Application No: AB/52/21/PL
Site Address: Old Bank House 3 High Street Arundel BN18 9AD
Description of works: Replacement of all windows with new timber double glazed sliding box sash windows and the proposed rendering of the South Elevation (front) with render painted white. This application affects the setting of a Listed Building and the character and appearance of the Arundel Conservation area.

Thank you for your internet representation made on 16th May 2021 which has been recorded as an objection with the comments as follows:

No.1 No.3
PROPOSED SOUTH ELEVATION (1:100)

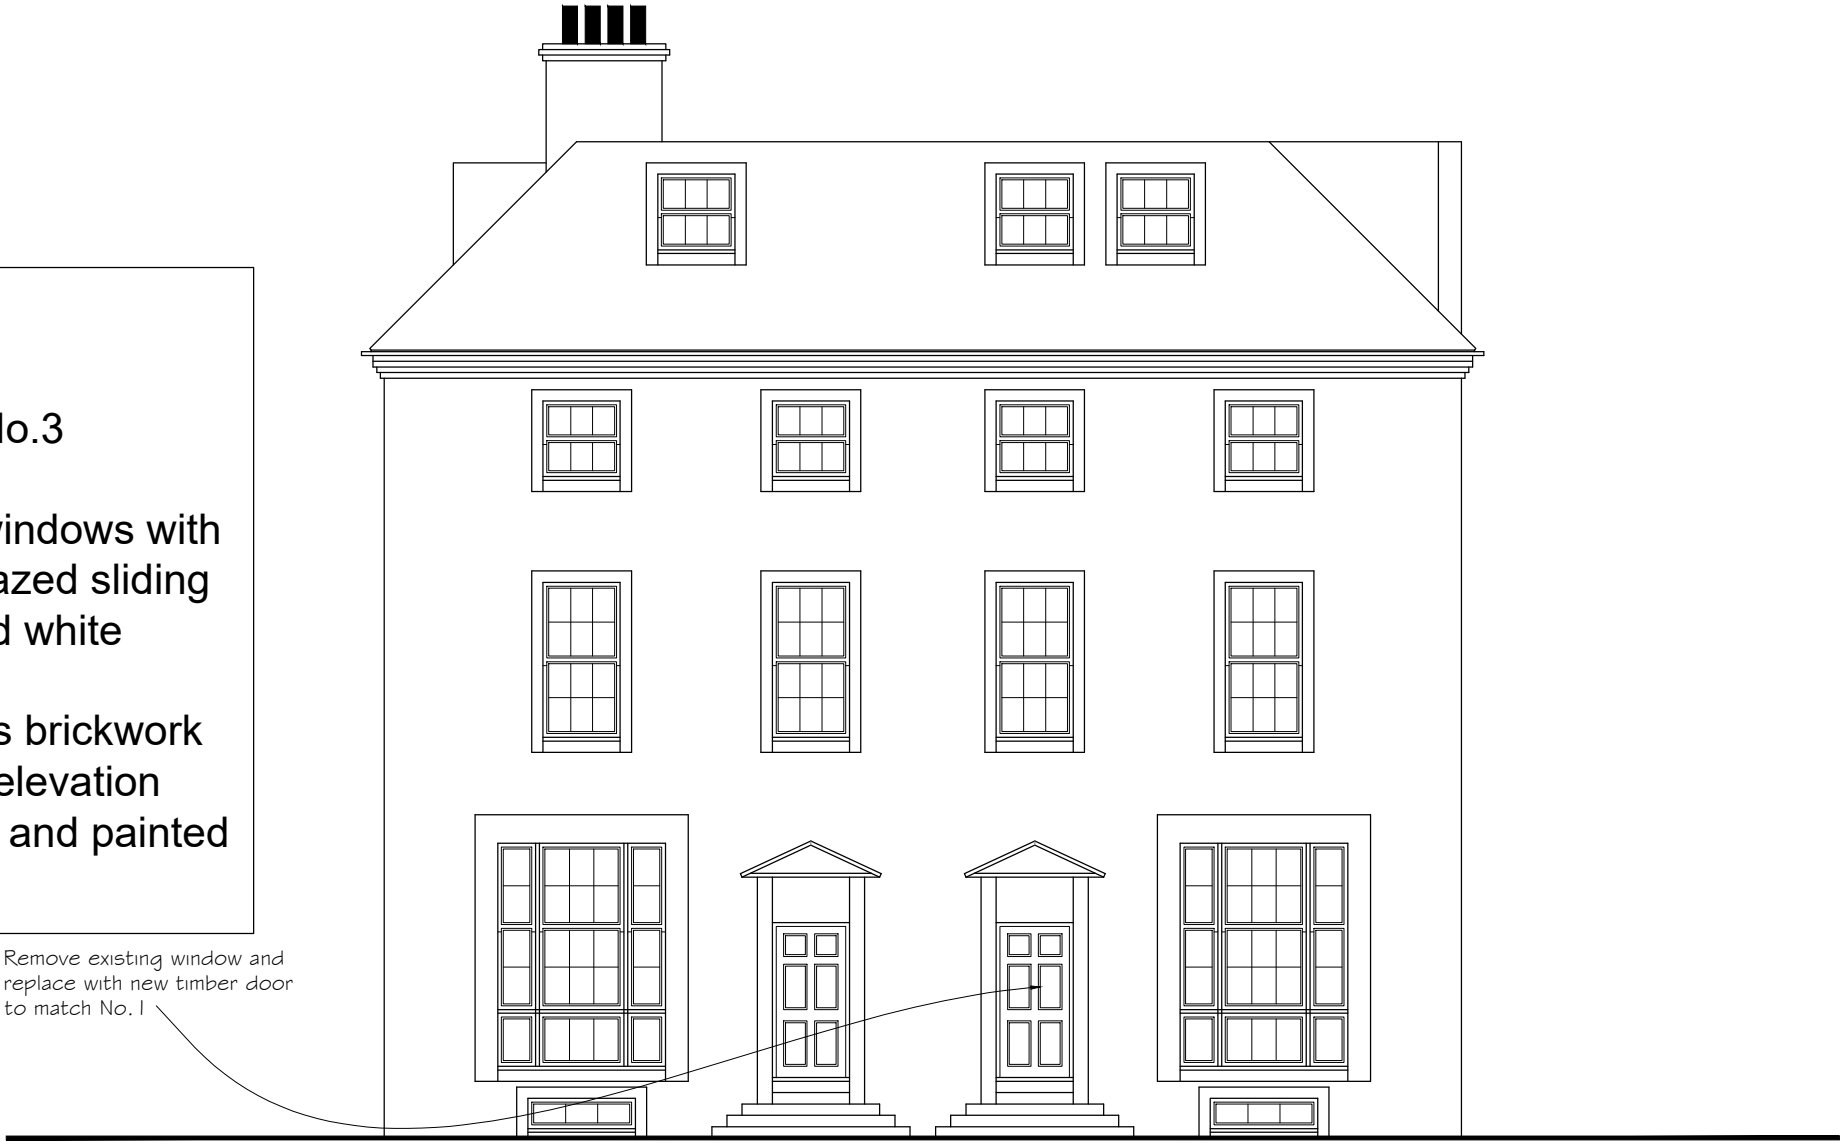
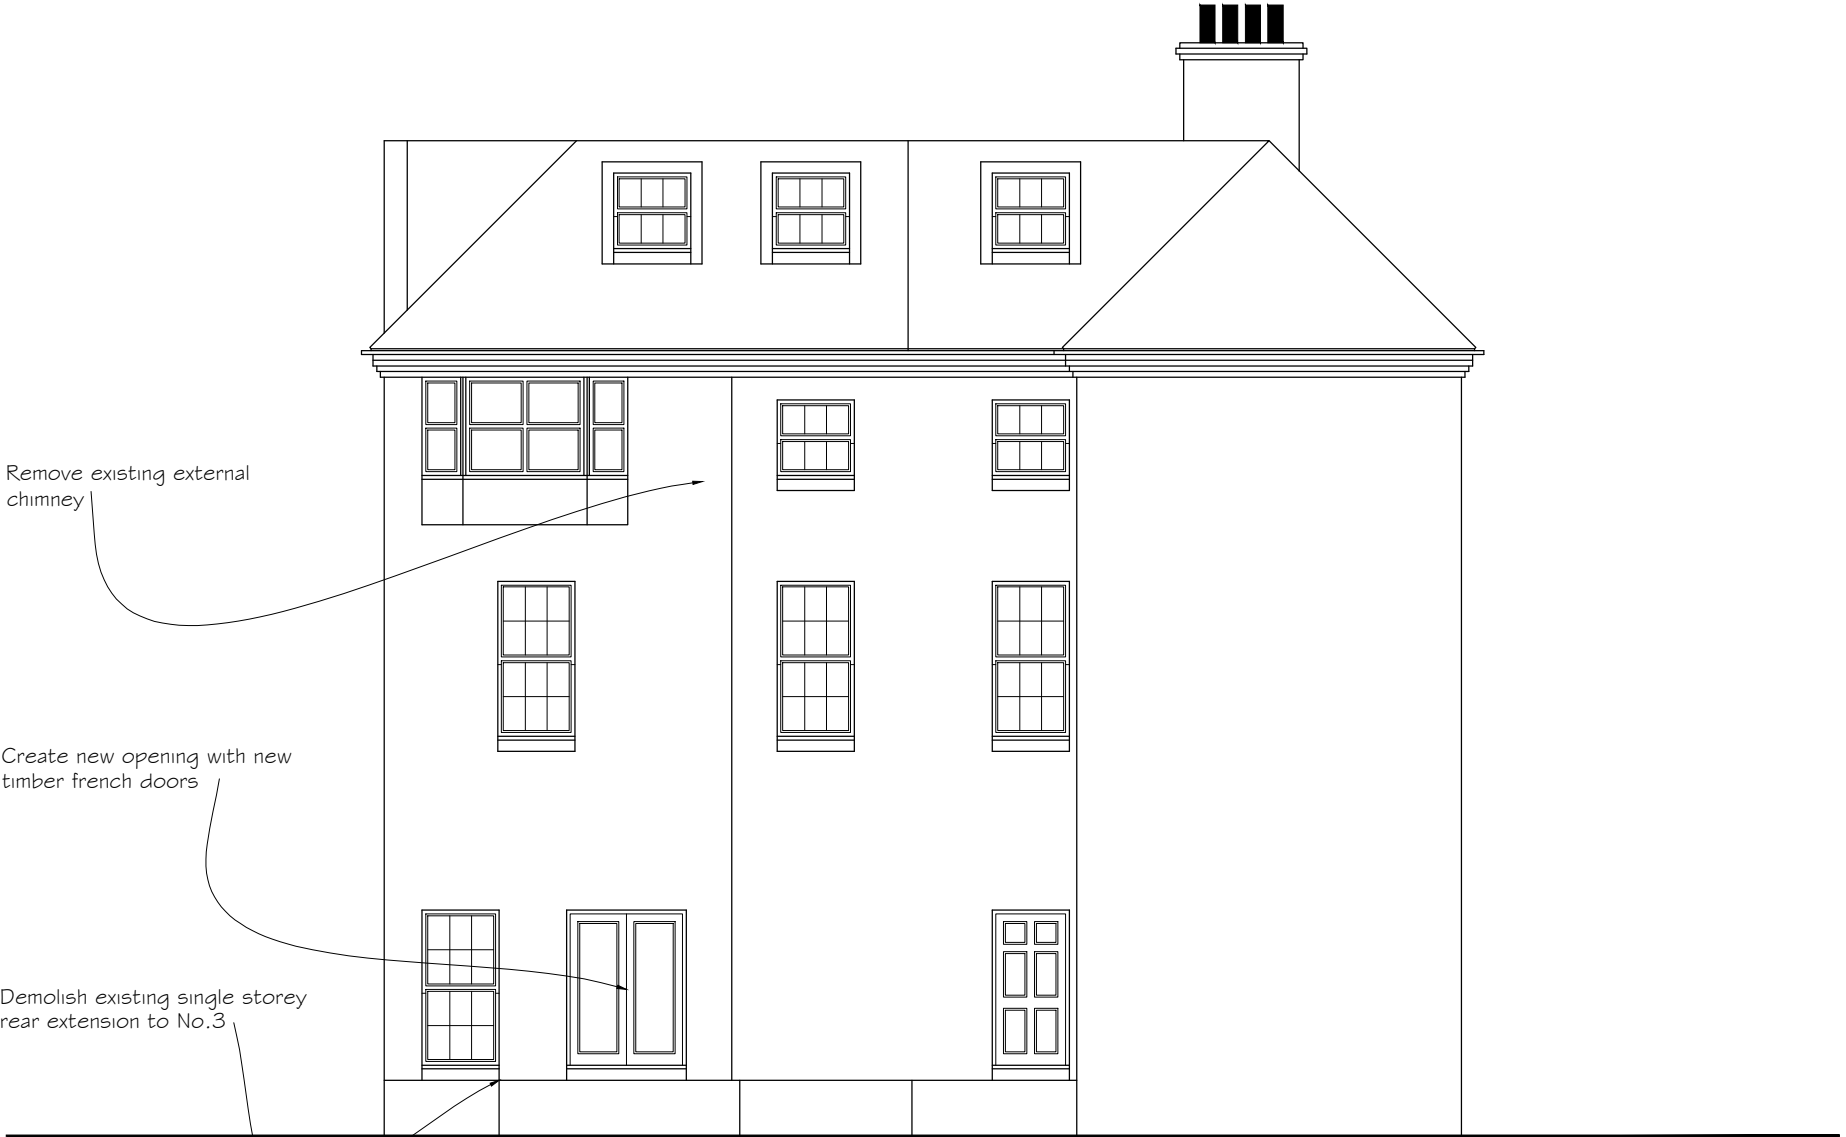
The Committee objected to the application on the grounds of affecting the street scene and that the windows should be in the original style using secondary glazing rather than using replacement double glazing.
